COMMUNITY DEVELOPMENT DEPARTMENT
501 Delta Avenue ♦ Marysville, WA 98270 ♦ (360) 363-8000

Re: Kids N' Us – *Tech Review 1*
PA23013

RE: Kids n Us, File# PA23-013
New Childcare Facility
8287 Soper Hill Road

SUBJECT: PA 23-013 White Barn-Kids N Us, March 2023 TIA &/or response#

A-1.00

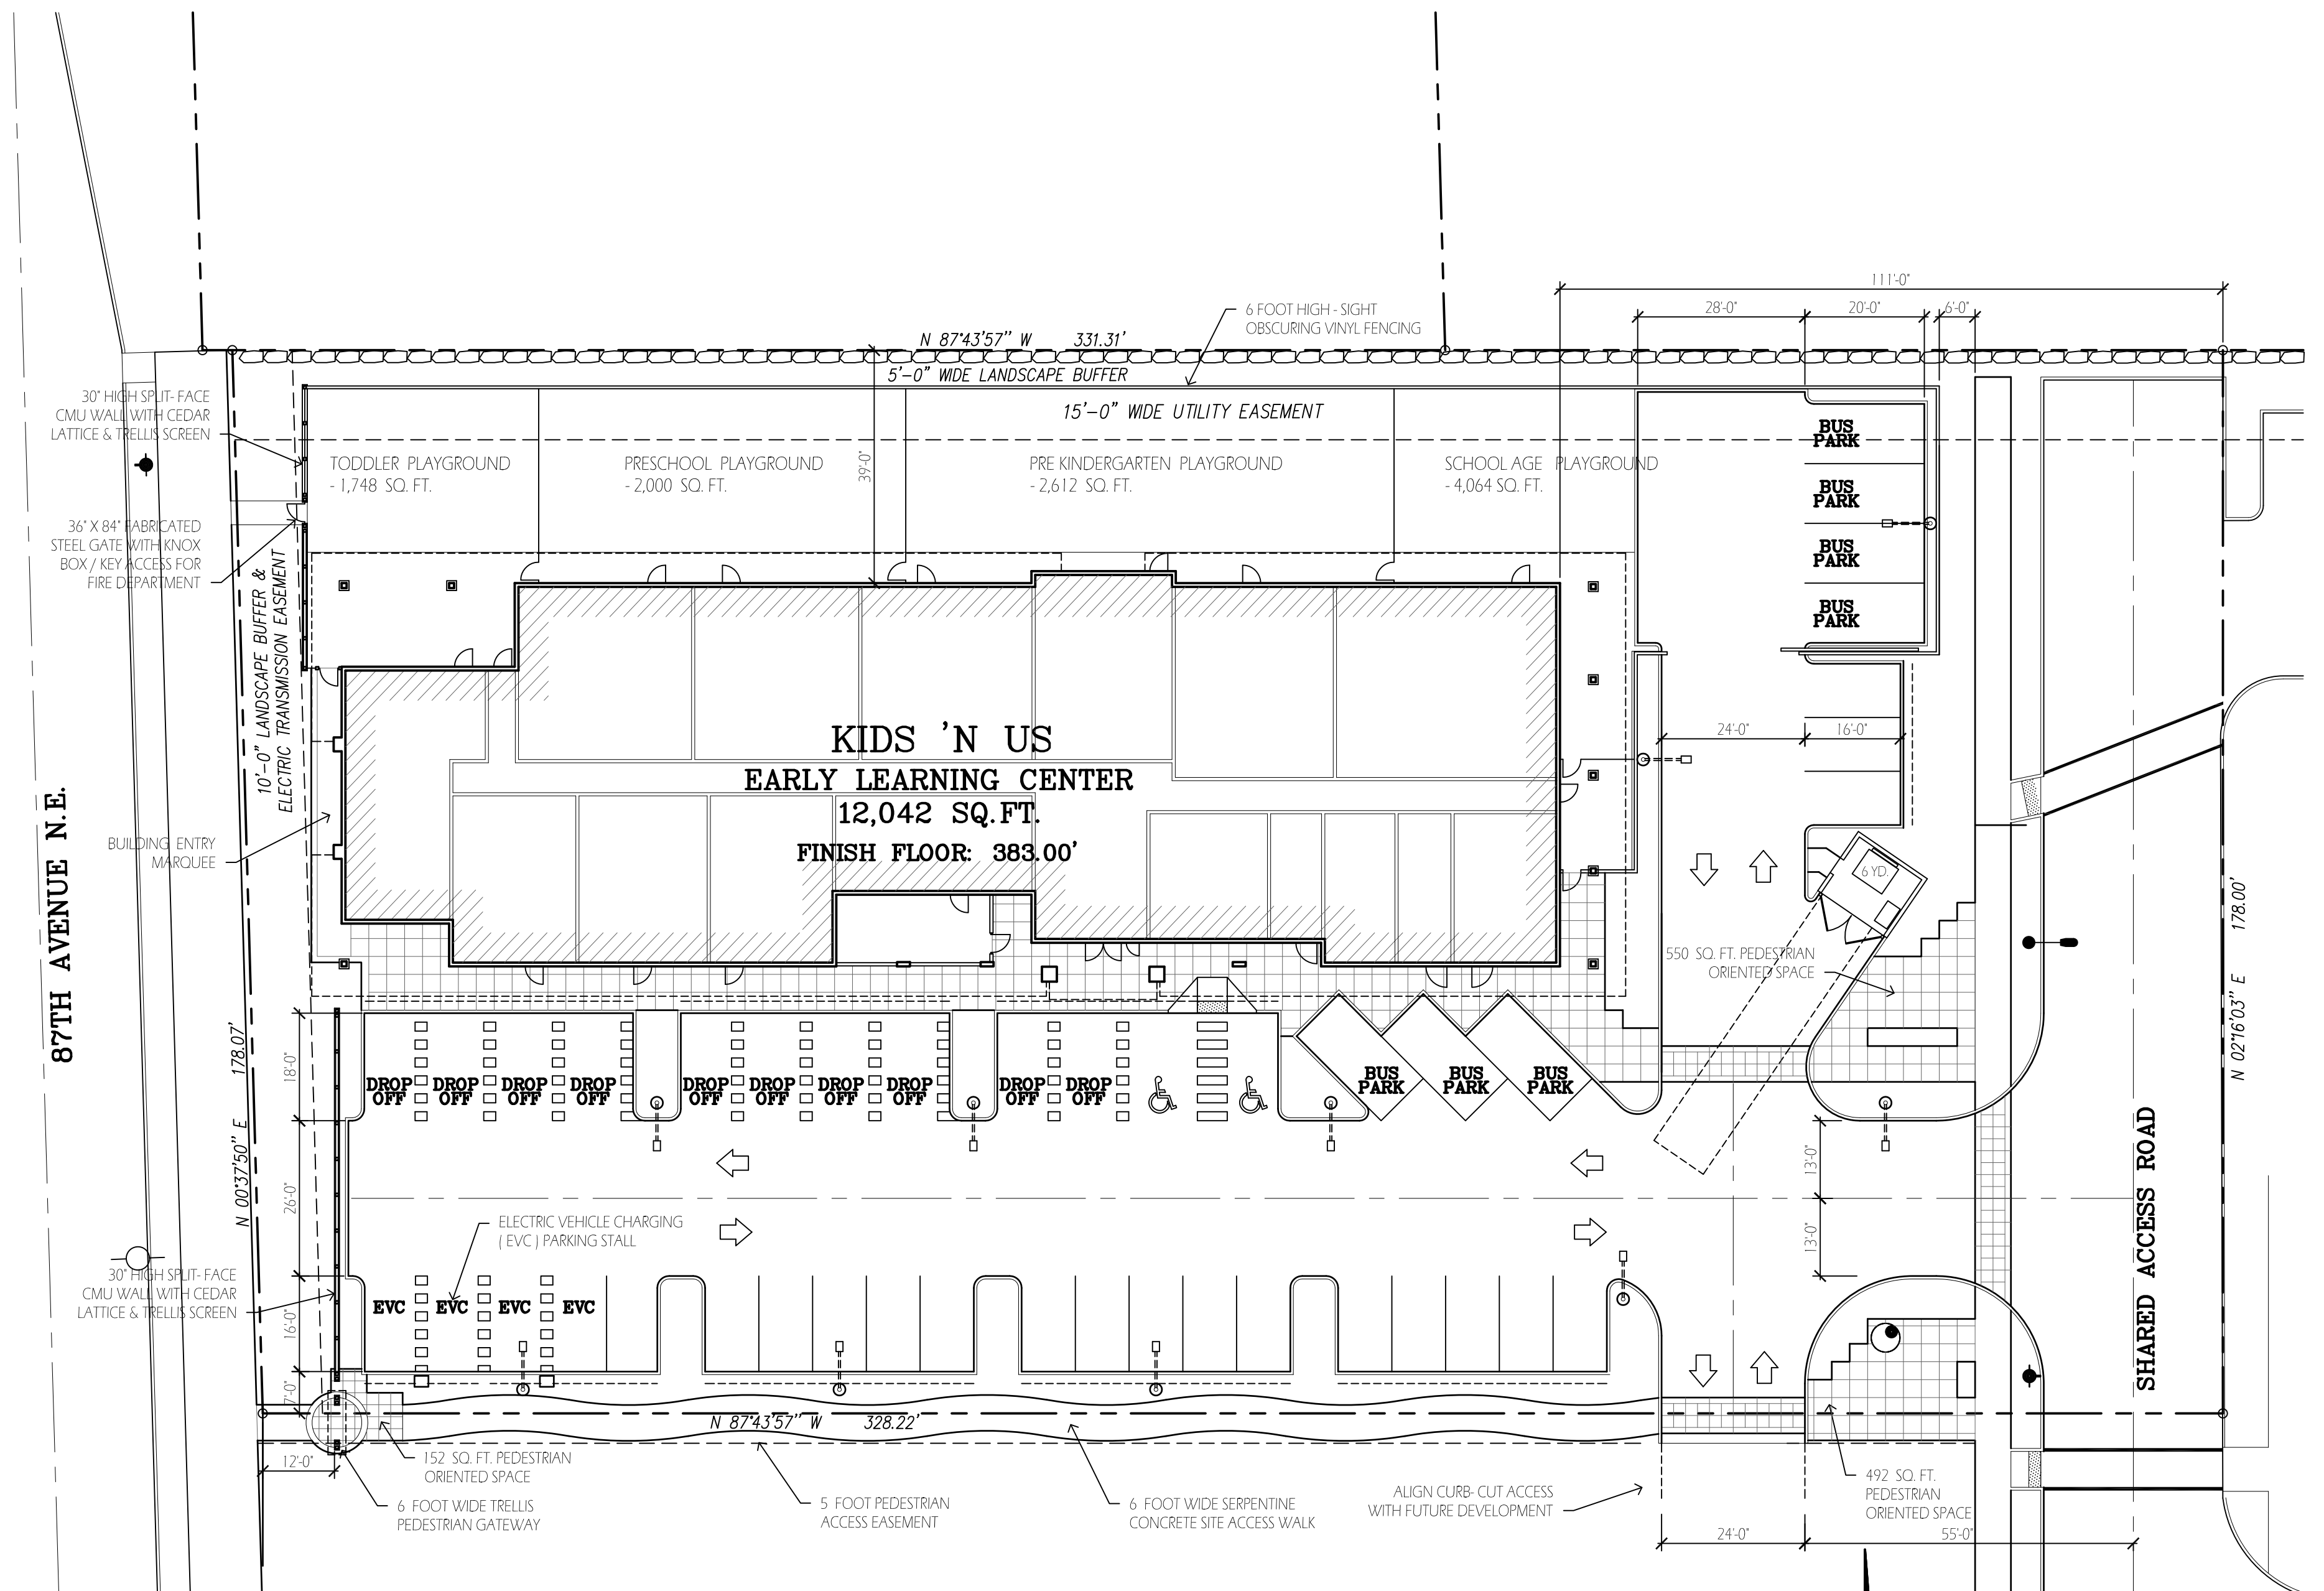
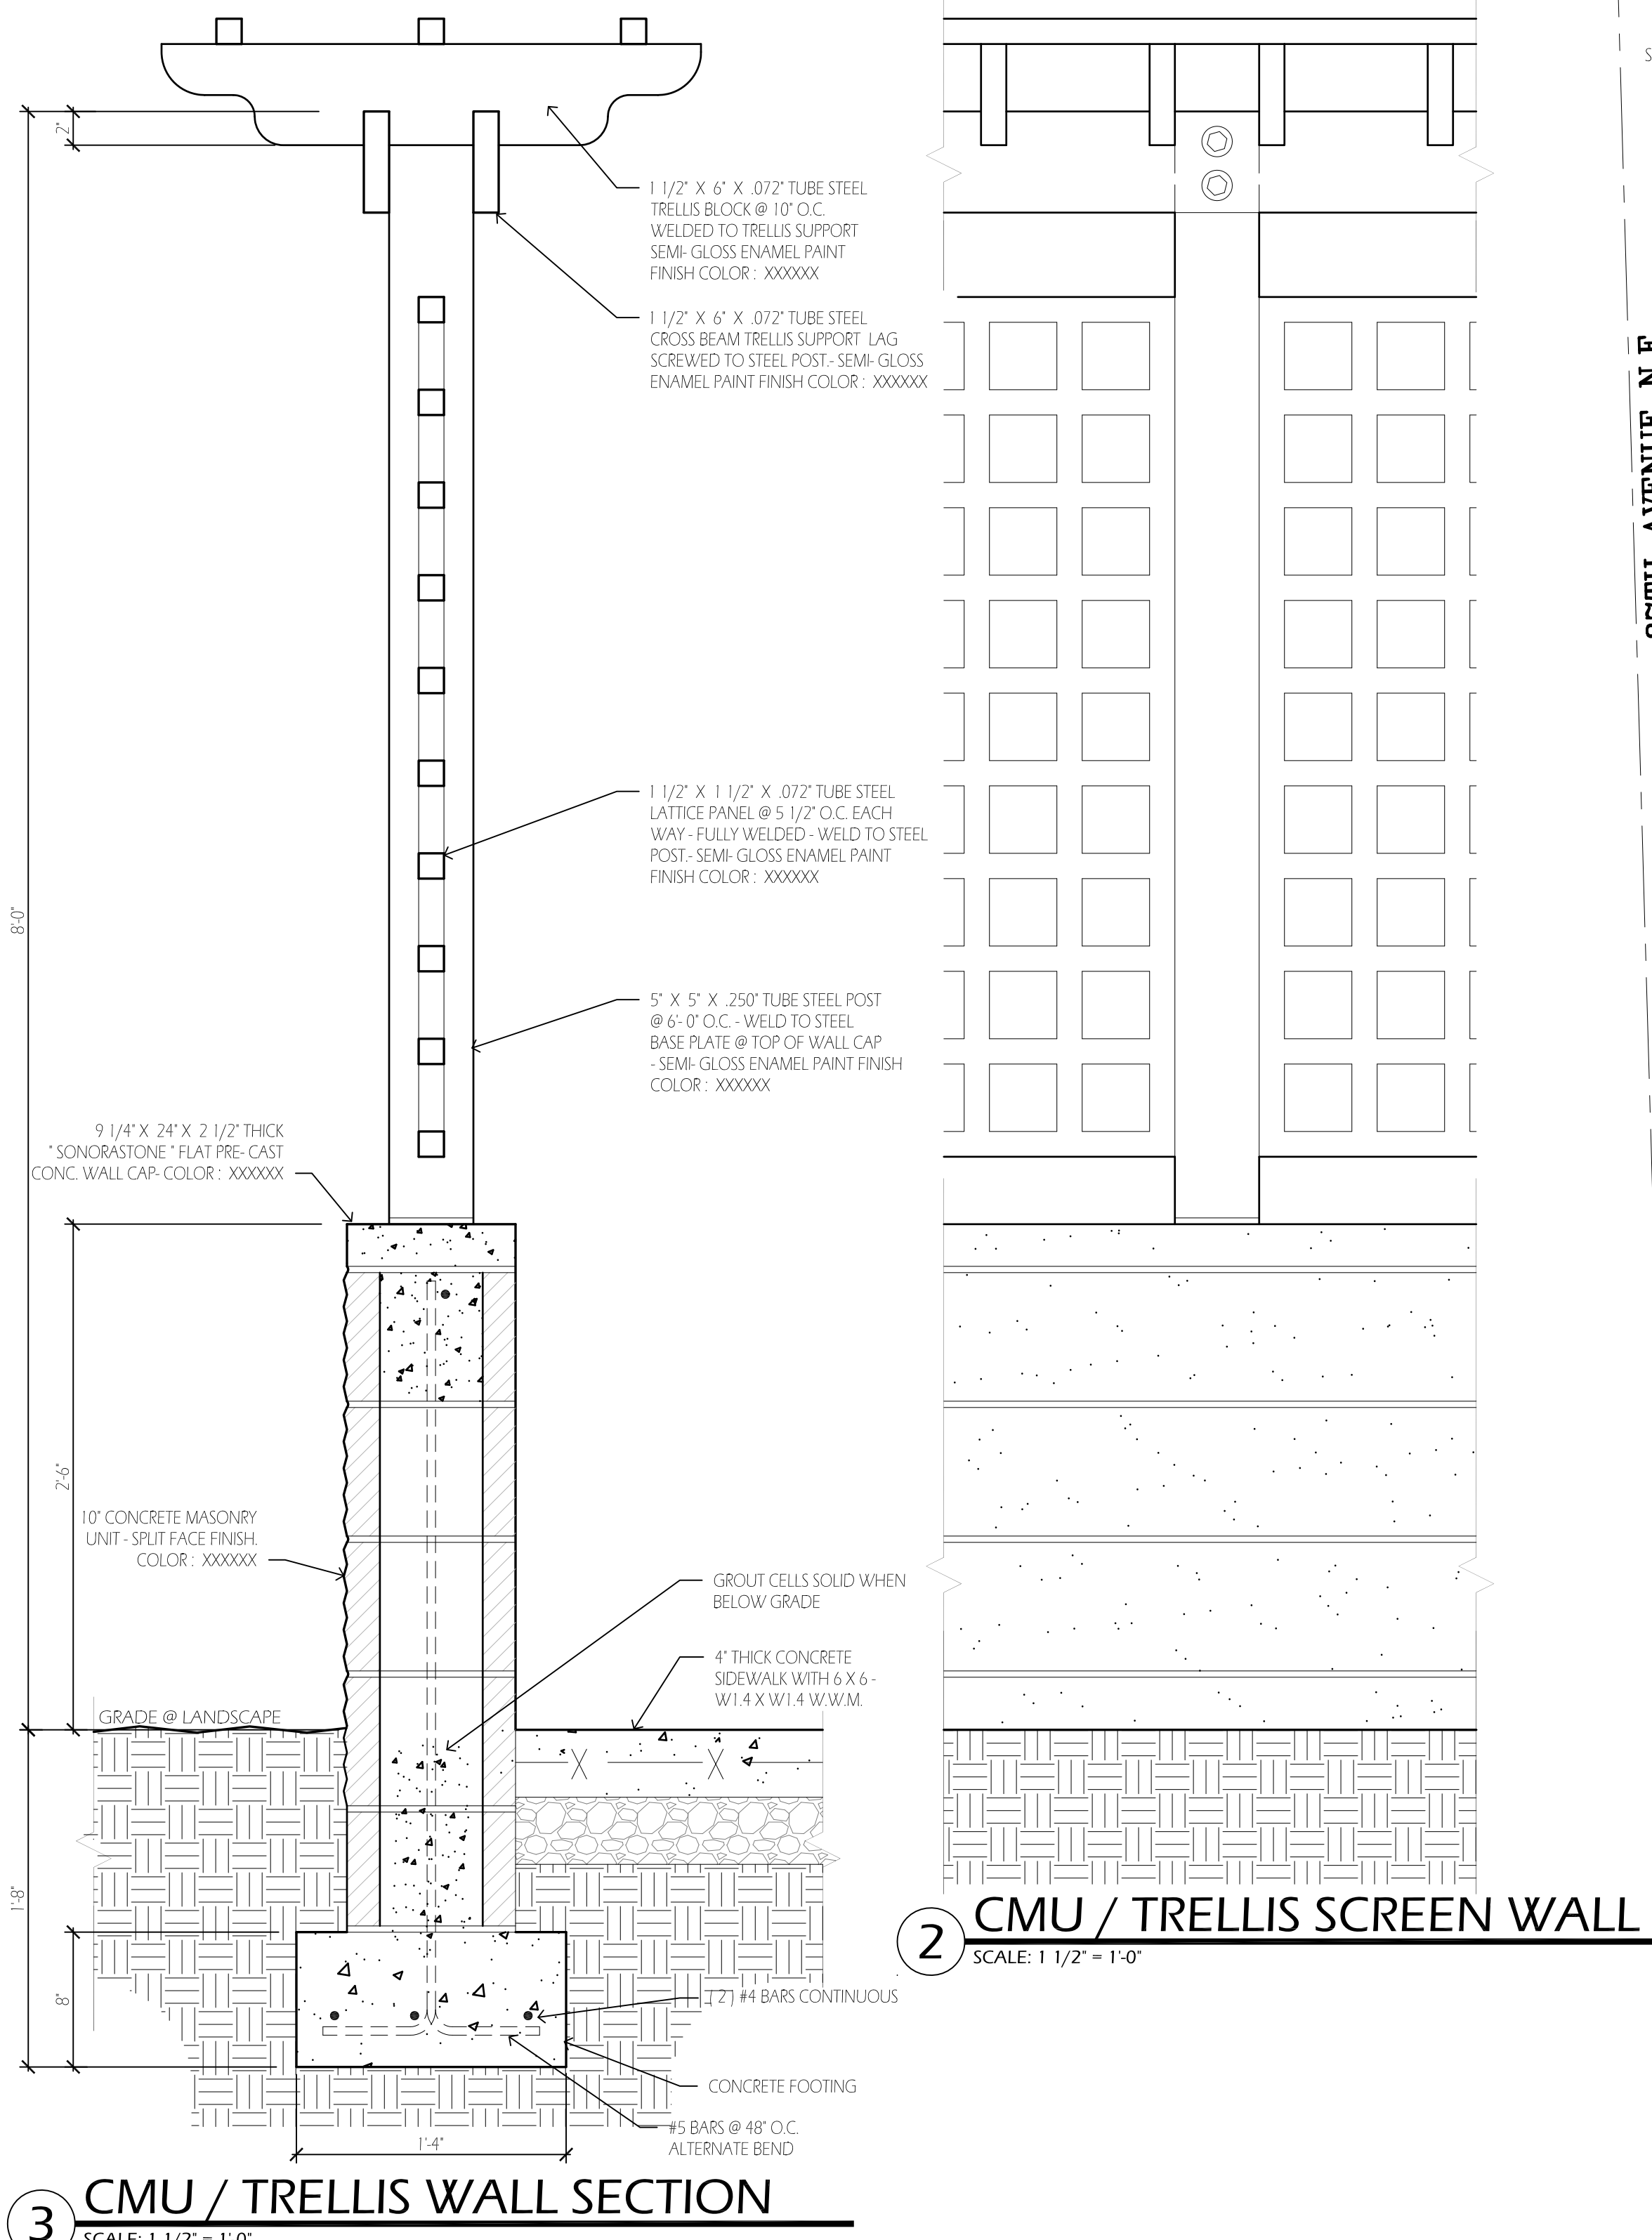
1. Include File No. PA23013 on all future plan submittals.
2. Amend Sheet A-1.00 and Sheet C-2.0, depicting all encumbrances (easements) outlined in the Title Report, prepared by Chicago Title Insurance Co., dated May 16, 2023. If you cannot depict the easement then provide a reference including Auditor's File Number.
3. Amend the landscape plan to include columnar shaped deciduous trees 5' from the back of sidewalk on 87th Avenue NE planted at a rate of 1 per 40'.
4. Submit a photometrics plan and design specifications for the proposed site lighting to determine compliance with [MMC 22C.070.160](#).
5. Submit color elevation drawings with your formal building permit submittal in order for the Planning Division to conduct design review to ensure compliance with applicable standards outlined in [MMC Chapter 22C.070 East Sunnyside – Whiskey Ridge Subarea – Design Requirements](#).
